From: Contact Centre (CRM) <contact@ribblevalley.gov.uk>
Sent: 26 August 2025 20:30
To: Planning
Subject: Planning Application Comments - 3/2025/0588 FS-Case-744018841

Planning Application Reference No.: 3/2025/0588

Address of Development: Land east of Clitheroe Road Whalley

RE: REPRESENTATION TO APPLICATION 3/2025/0588

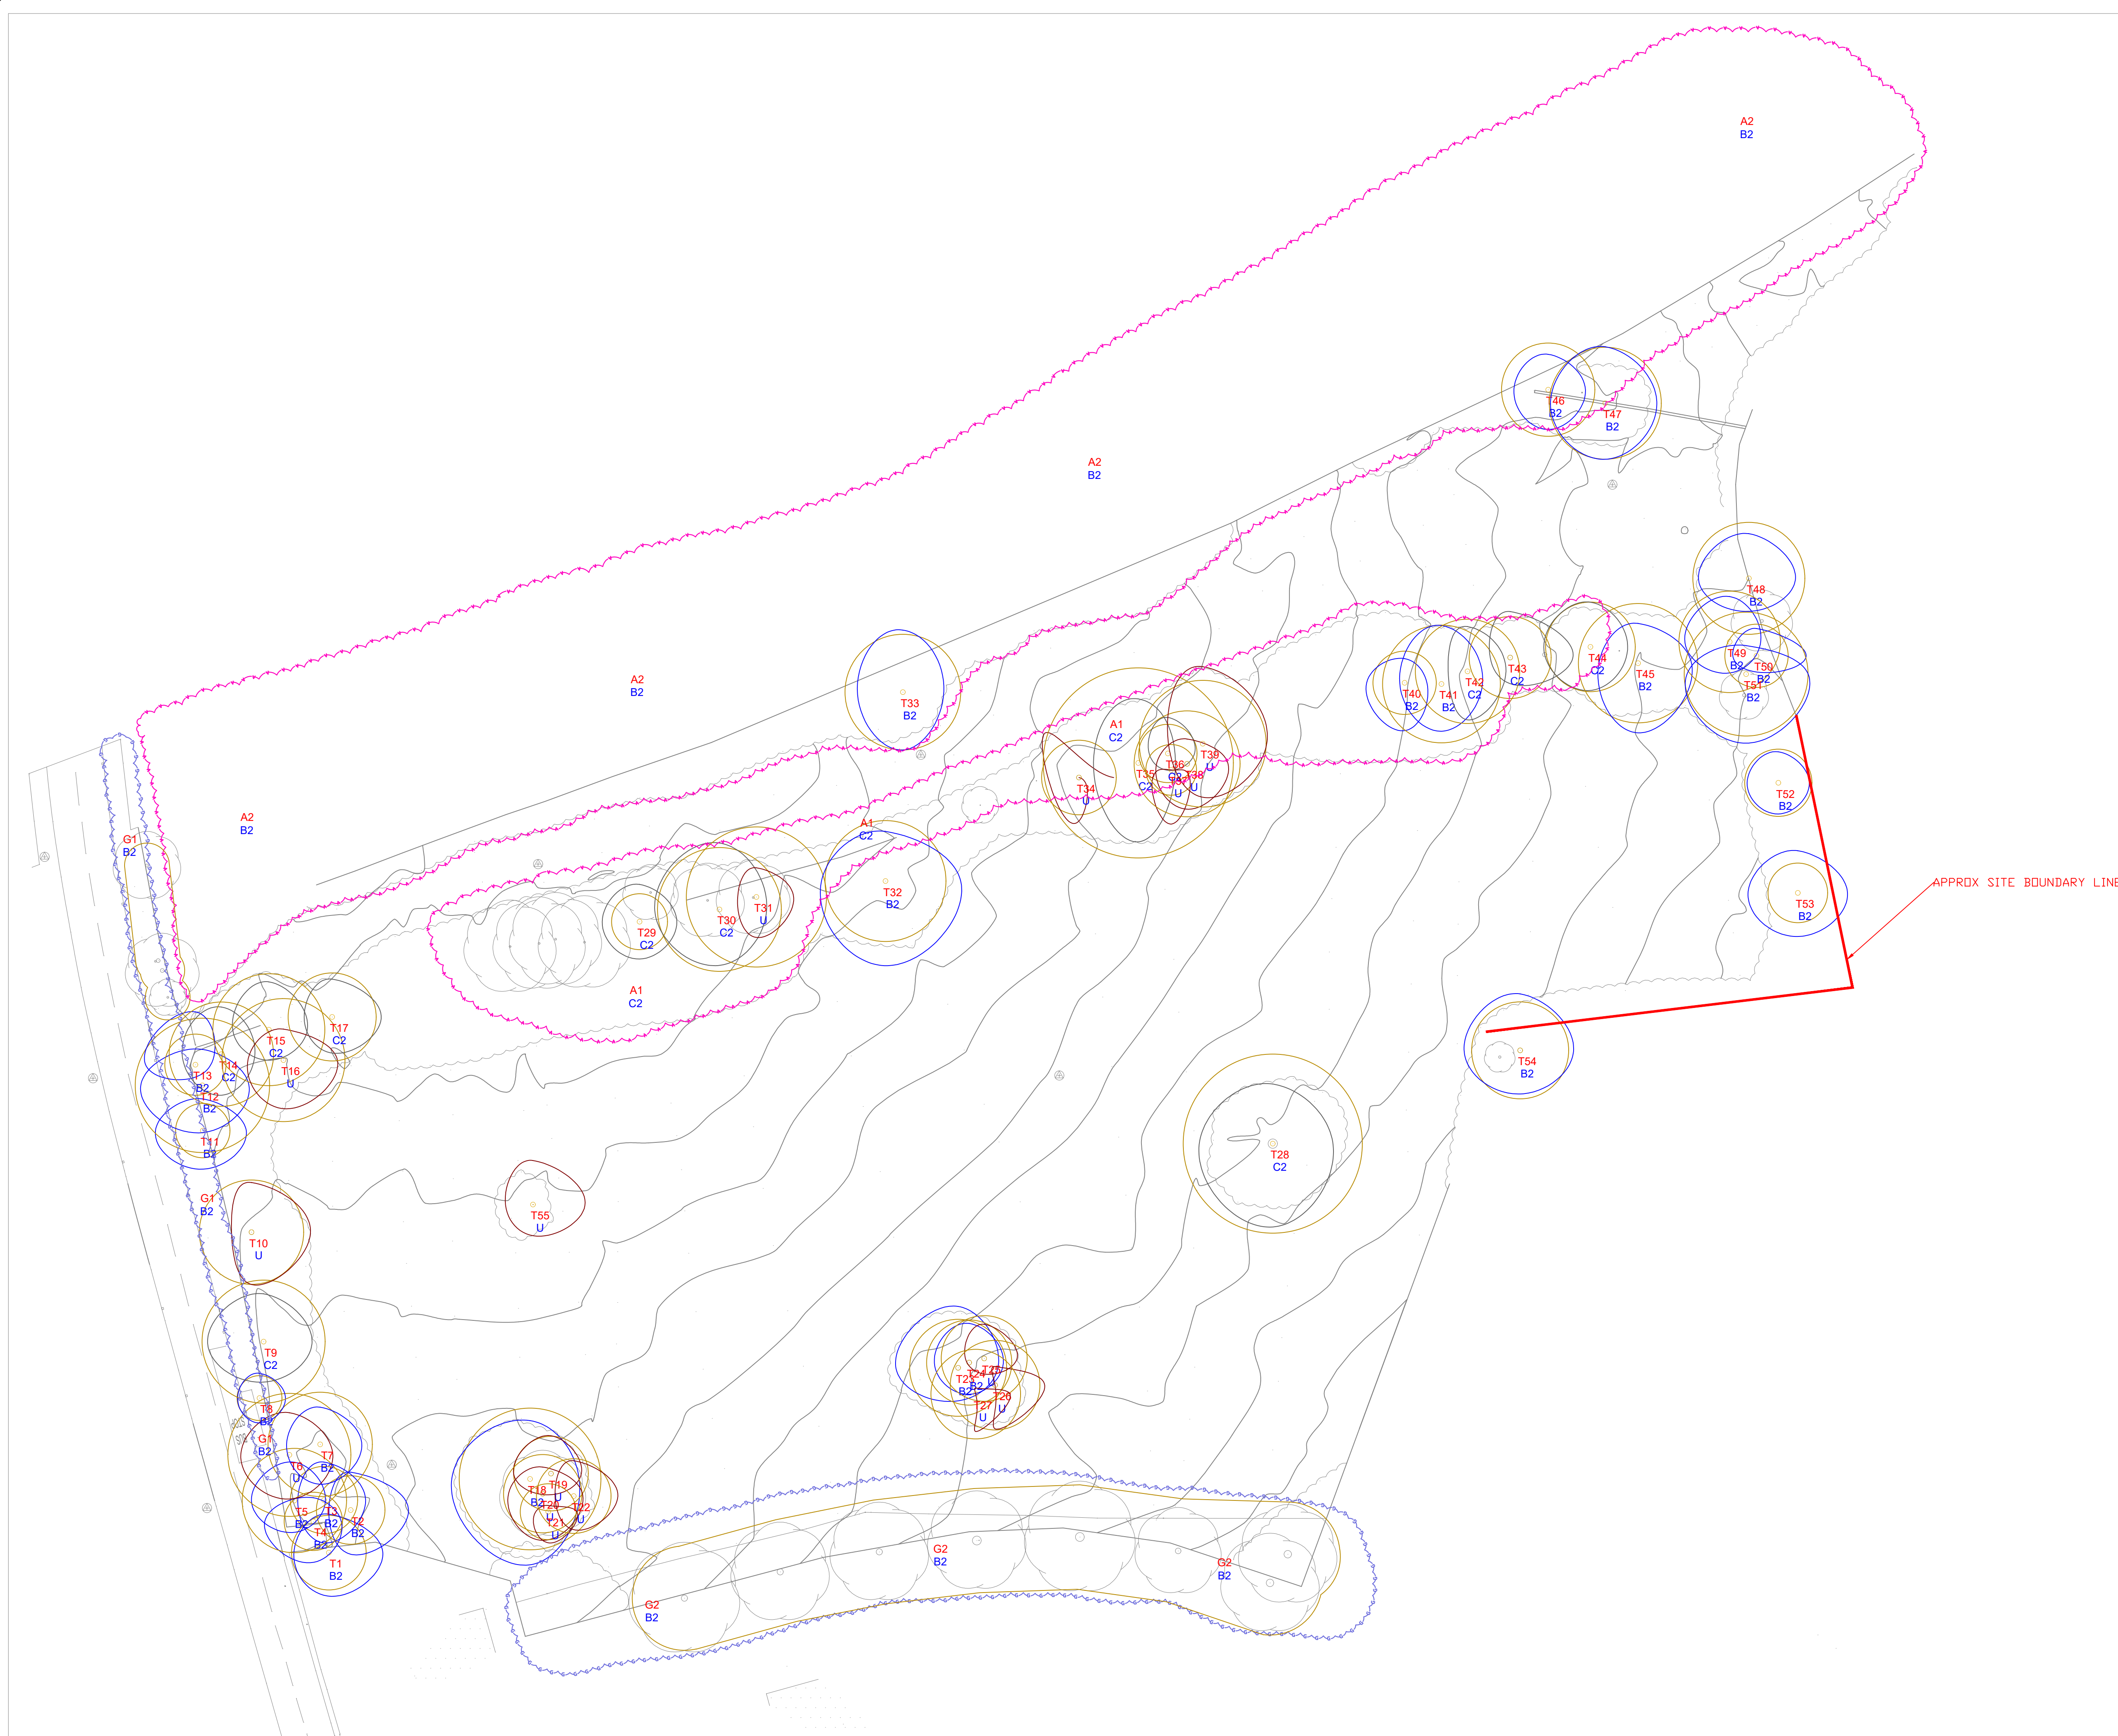
Protected trees: Three mature TPO lime trees sit within falling distance of proposed plots and are not adequately safeguarded.
